Hearing Action Points

London Pilots Council (LPC)

Deadline 5 Submission

29th April 2019

Sea Zones Plan – Reduction in red line boundary

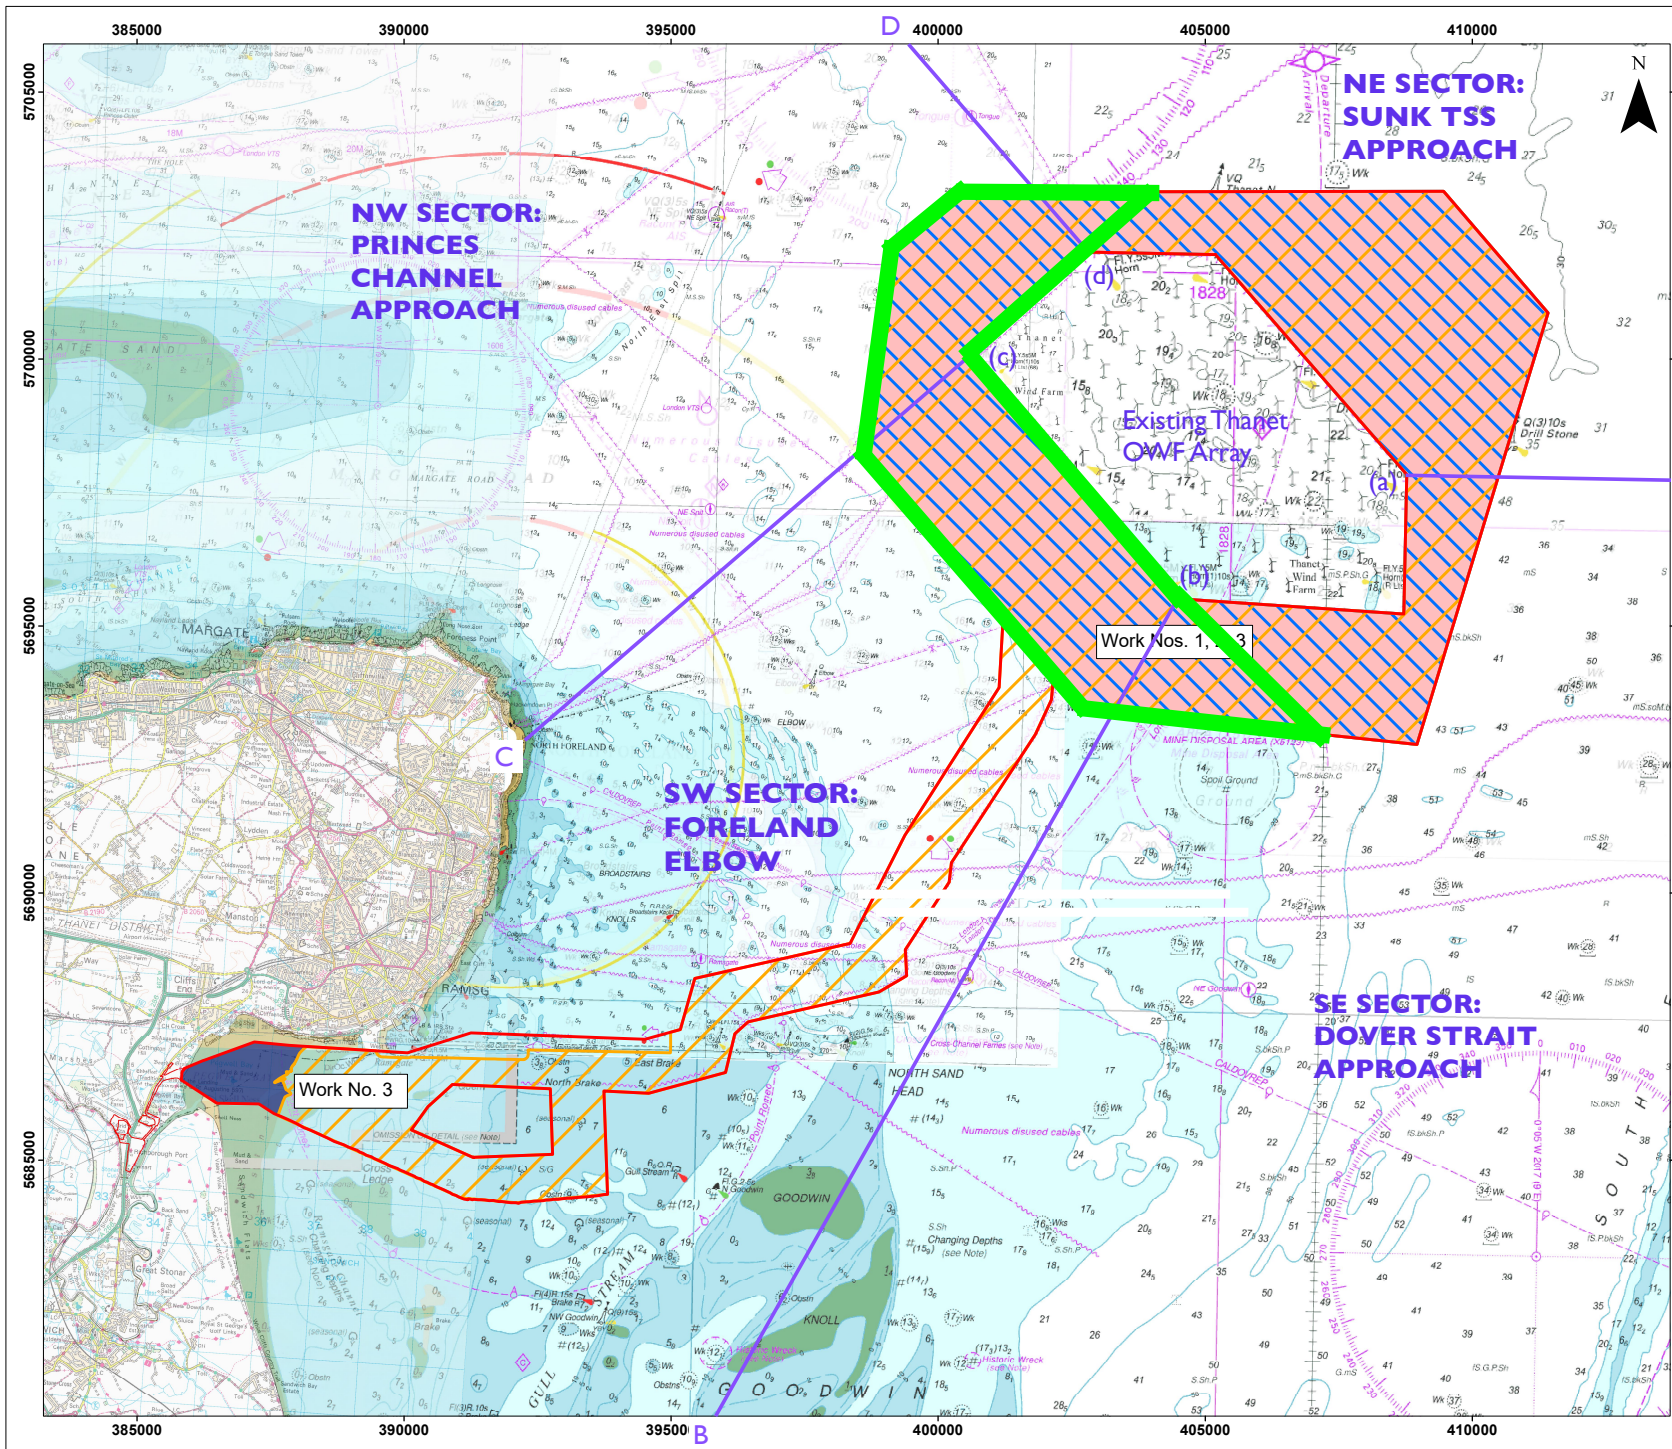
1. Revised red line boundary

1.1 The LPC were asked to provide clarification of a sketch in their Deadline 4 submissions which showed a preferred red line boundary in order to maximise sea room at the NESP for manoeuvring large vessels, as shown in Fig.1

2.1 The LPC are concerned that the Applicants proposed red line boundary does not allow sufficient sea room for manoeuvring large vessels at the NESP particularly in the contentious area or choke point, to the SE of the NESP Racon.

2.6 Combining all of these factors then it is not in the best practice of seamanship or vessel safety to initiate and complete a manoeuvre requiring a large change of heading of a ULCS for a Pilot in less than 2 miles sea room. The time and distance factor for margin of error is very small and as such the LPC require a minimum 1 mile SEZ in addition to the two miles sea room as shown in Fig.B.

2.9 Traffic management is required to maintain two miles of sea room and a practical amount of buffer zone between the operational sea room and the existing Windfarm to ensure a safe operation. The LPC require a minimum of 2 miles of sea room and a 1 mile of safety buffer zone to safely operate vessels of this type at the NESP.

3.4 The red line boundary proposed by the applicant removes any margin the Pilot may have had for speed and position, traffic density or heading allowance for weather.
